DECISION DELEGATED TO HEAD OF PLANNING

Application No: H18-0309-24 **Applicant:** Mr D Bunn

Proposal: Residential Development - Erection of Pair of Semi-Detached Houses - approved under H18-0722-22. Modification of Condition 2 to allow amendments to previously approved plans.

Location: Former Conservative Club Hall 2 New Road Sutton Bridge

SITE LAYOUT

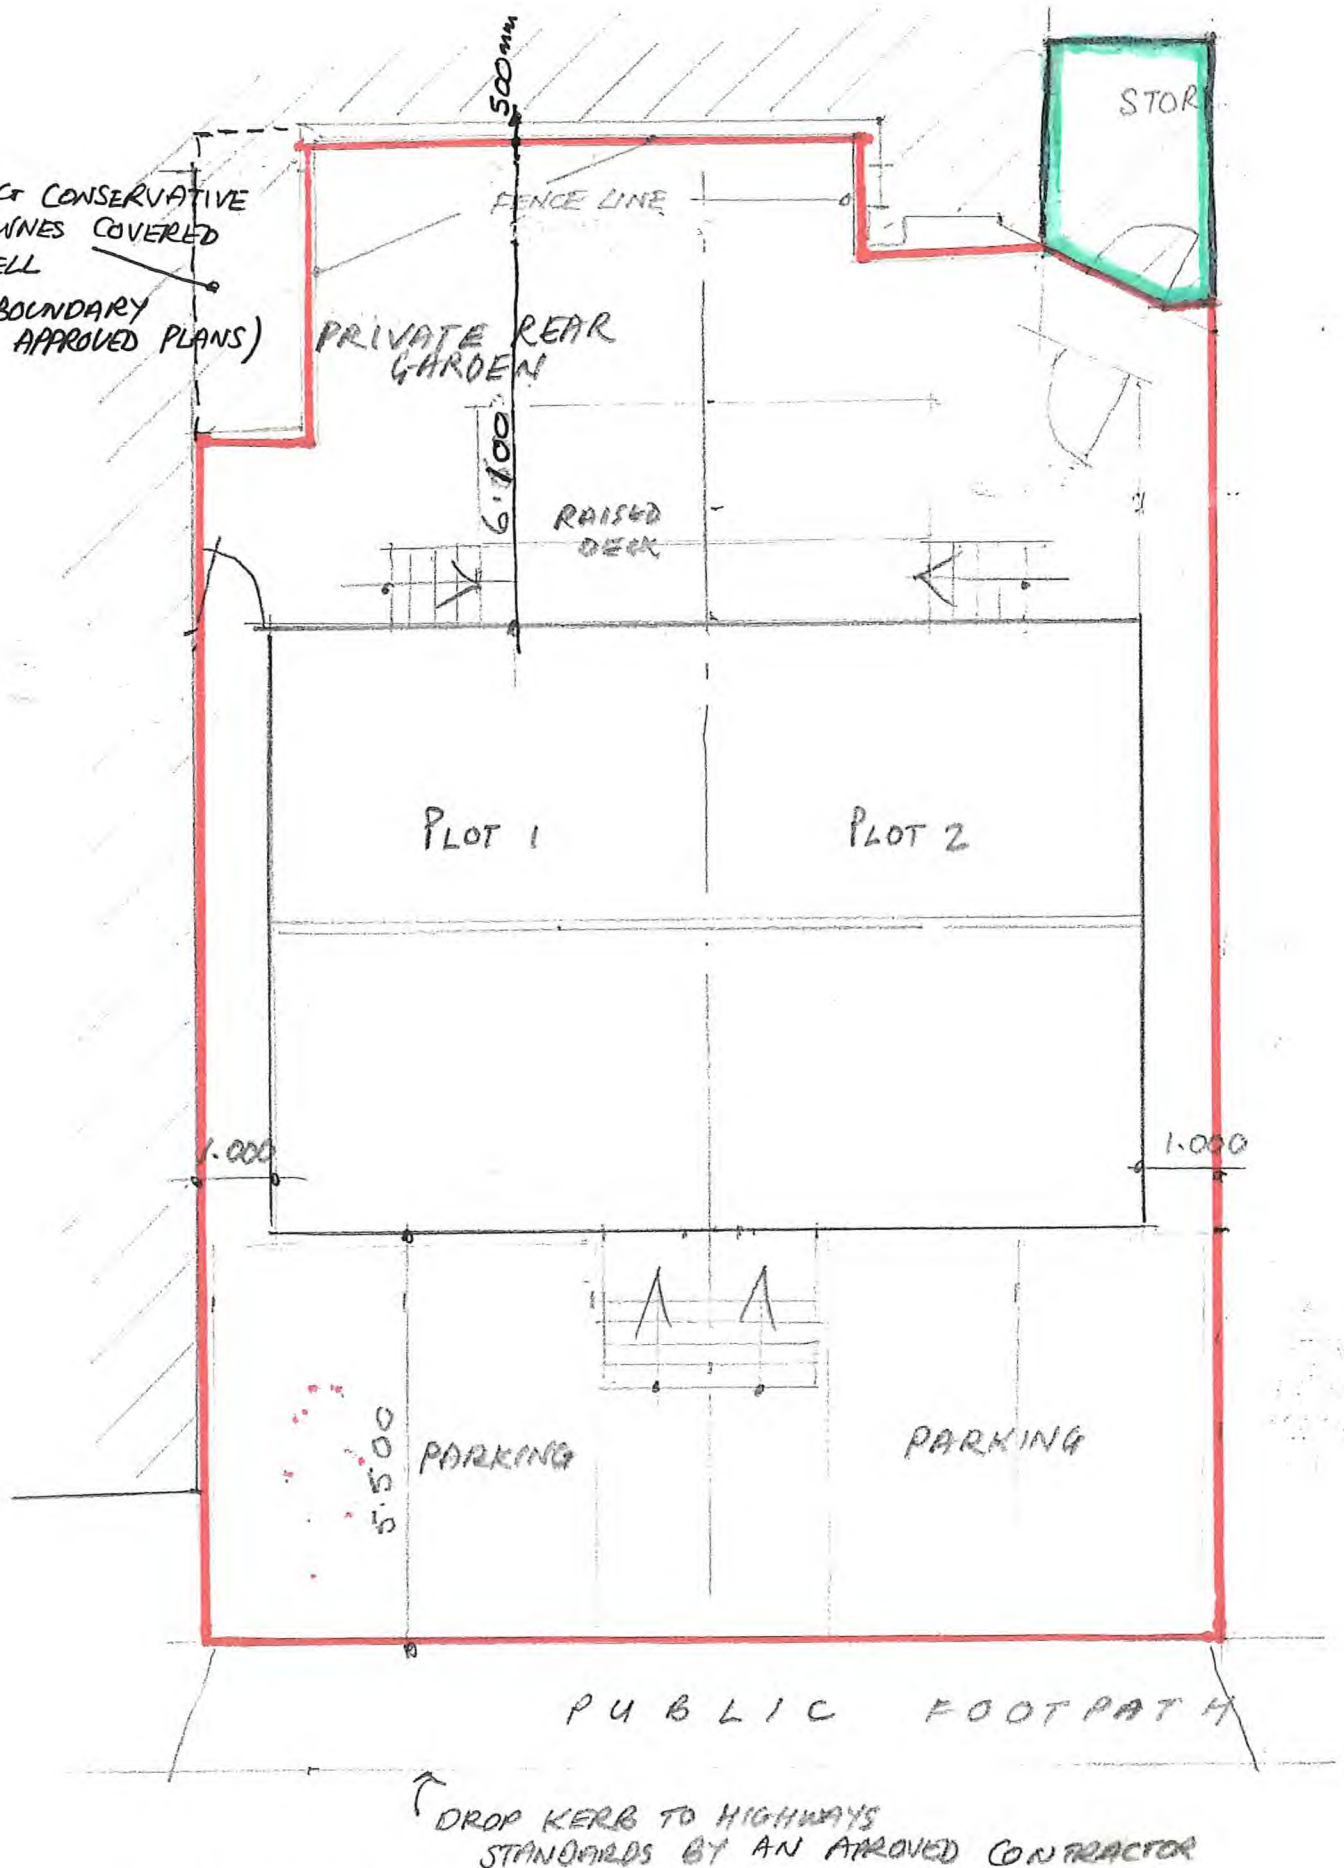
From the plans provided it appears the only change this Section 73 applications attempts to make is to the proposed red line boundary, in this they will be making it slightly smaller by bringing the boundary edge closer to the proposed plots 1 and 2. The measurements on the previously approved plans shows the distance from the plots to the rear boundary being at around 6500mm where as the new plans are 6100mm. Furthermore, the site location plan also shows these changes, plans on multiple previous applications for this site cover the entire site in red with the new site location plan bringing it away from the rear corners as this is supposedly the adjoining conservative clubs covered stairwell with the previous plans showing that it was part of this site. These amendments therefore aim to bring up and reduce any existing discrepancies throughout.

Due to the minimal changes proposed, these will not cause any material or substantial harm to the street scene or residential amenity. No changes are proposed to the layout, design or size of the plots that could cause any harm themselves. It is therefore considered to be acceptable in this instance.
